**EL PASO COUNTY PLANNING AND
 COMMUNITY DEVELOPMENT
 DEPARTMENT**

GRADING AND EROSION CONTROL PLAN CHECKLIST

Creekside South at Lorson Ranch

Revised: July 2019

CREEKSIDE SOUTH AT LORSON RANCH  
OVERLOT EARLY GRADING AND  
EROSION CONTROL PLAN

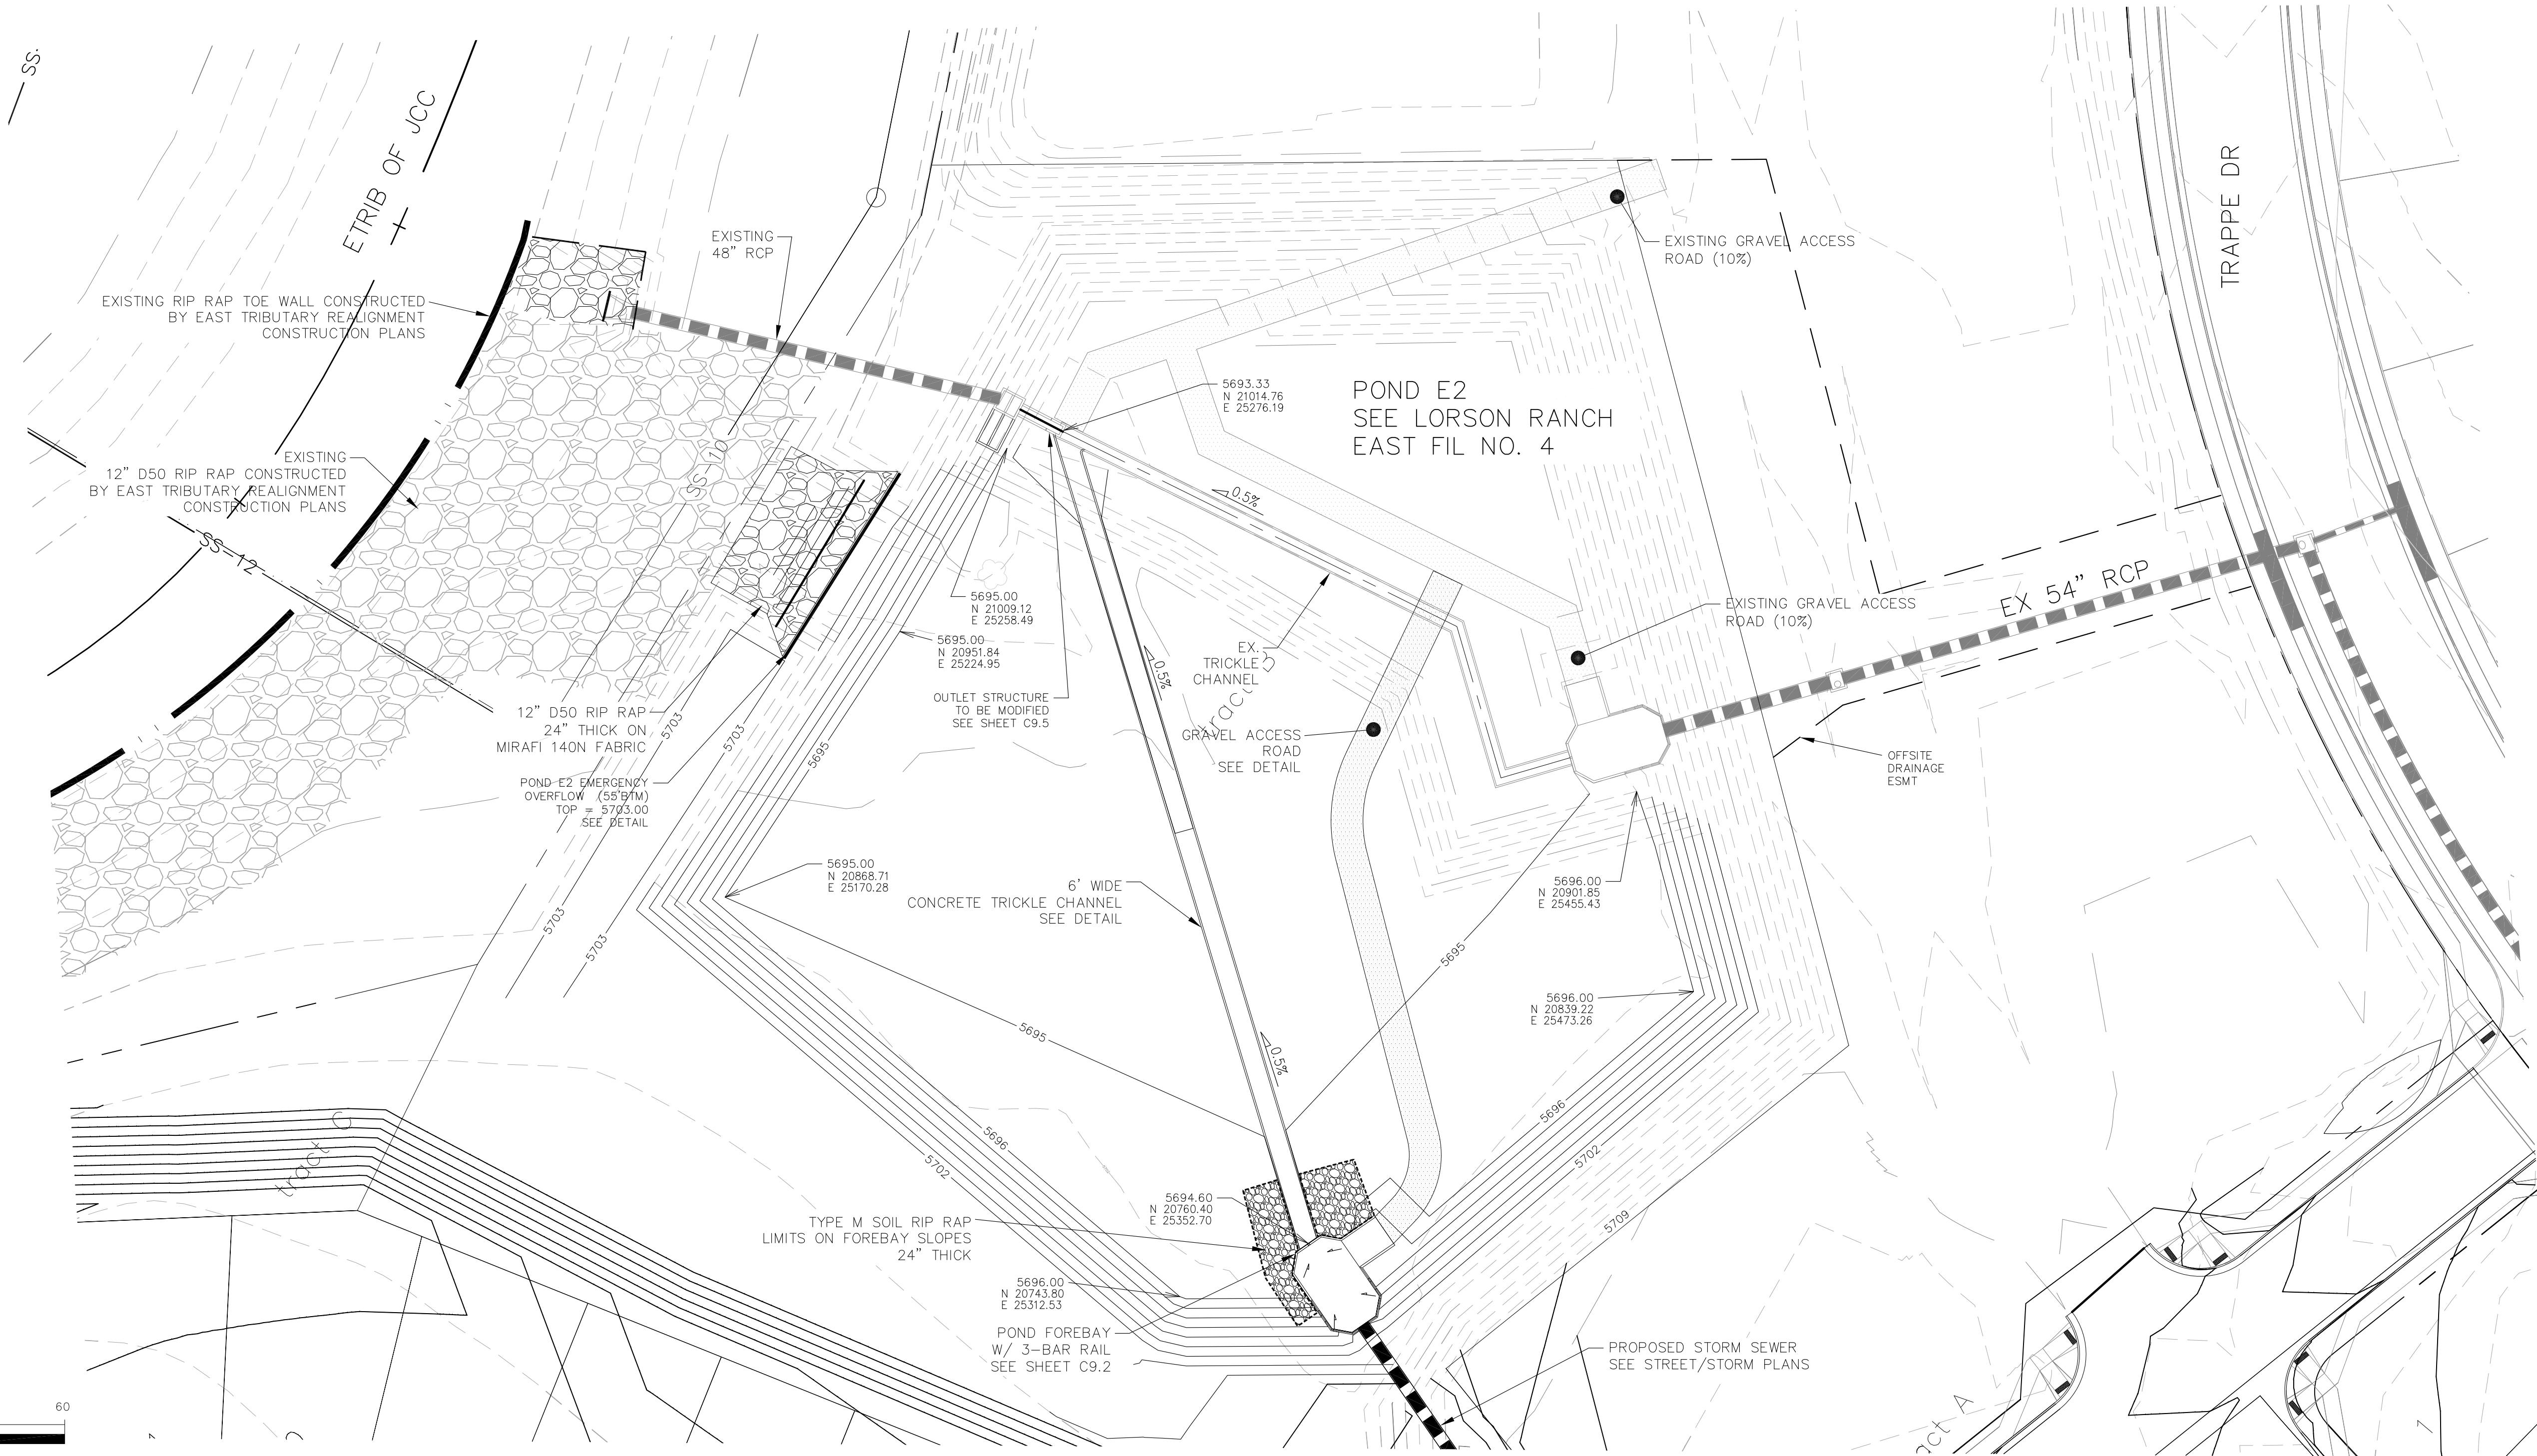
l	Existing and proposed contours 2 feet or less (except for hillside).	y	✓
m	Limits of disturbance delineating all anticipated areas of soil disturbance.	y	✗
n	Identify and protect areas outside of the construction site boundary with existing fencing, construction fencing or other methods as appropriate.	y	✓
o	Offsite grading clearly shown and called out.	n/a	N/A
p	Areas of cut and fill identified. (See Notes)	y	✓
q	Conclusions from soils/geotechnical report and geologic hazards report incorporated in grading design (slopes, embankments, materials, mitigation, etc.)	y	✓
r	Proposed slopes steeper than 3:1 with top and toe of slope delineated. Erosion control blanketing or other protective covering required. (There are no areas steeper than 3:1)	n/a	N/A
s	Stormwater flow direction arrows.	y	✓
t	Location of any dedicated asphalt / concrete batch plants.	n/a	N/A
u	Areas used for staging, storage of building materials, soils (stockpiles) or wastes. The use of construction office trailers requires PCD permitting.	y	✓
